PL- Consultation- Ecology response

From: Jonathan Best <Jonathan.Best@arun.gov.uk>
Sent: 22 April 2026 10:18
To: Planning.Responses <Planning.Responses@arun.gov.uk>
Cc: Harry Chalk <Harry.Chalk@arun.gov.uk>
Subject: M/20/26/PL

86 Ancton Way Middleton-on-sea PO22 6JP.

I have reviewed this application with regards to ecology and Biodiversity Net Gain.

PROPOSED SURFACE WATER DRAINAGE

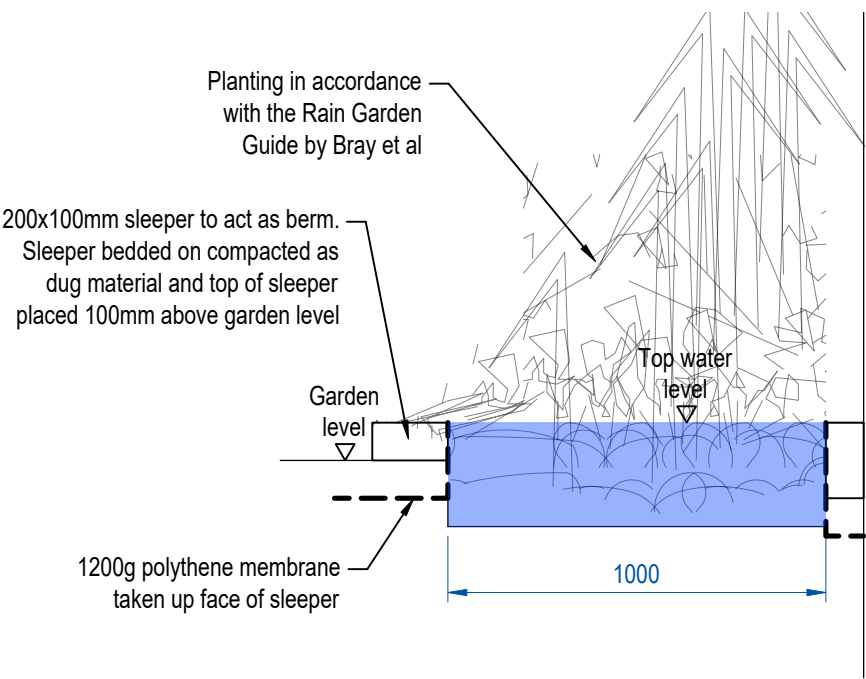
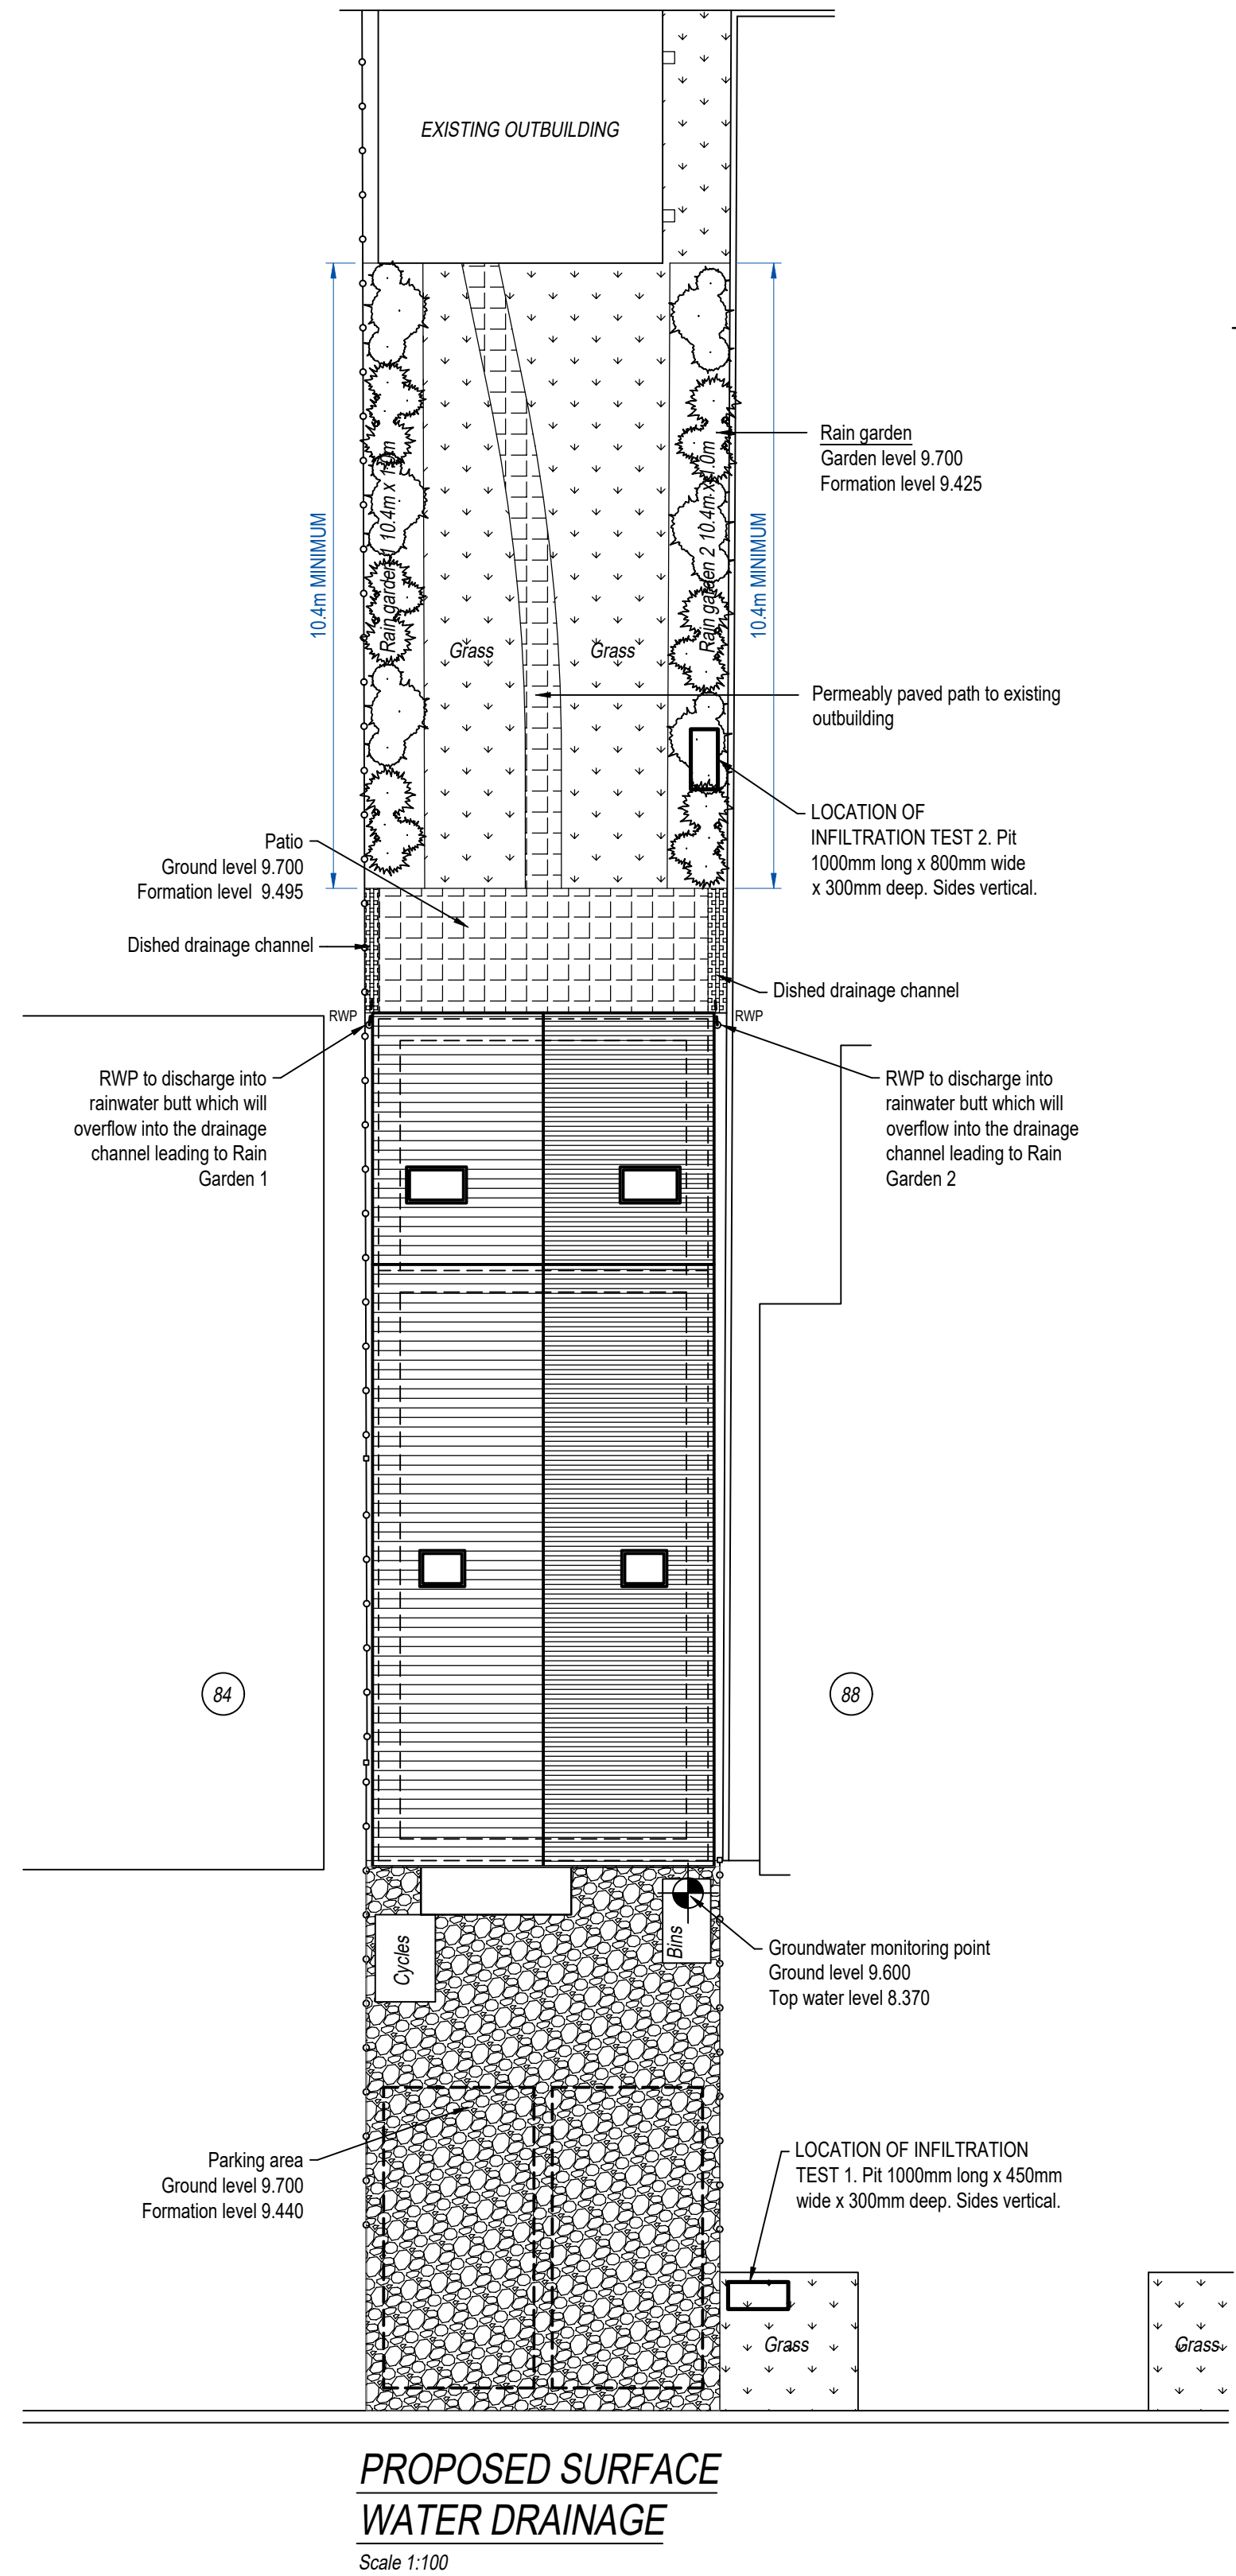
A Small Sites BNG metric has been submitted and shows a gain of 134.56%. This is based on a 60 m2 good condition Sustainable Drainage System being created.

The plans do not show a Suds system that matches this description.

Biodiversity gain that is compliant with our policies can be delivered through the inclusion of ecological features onsite.

Ecological enhancements are recommended. These include bat roost features, Bird boxes, bug hotels, log piles, hedgehog house and small mammal gaps in fencing.

I advise condition ECOBNG2.
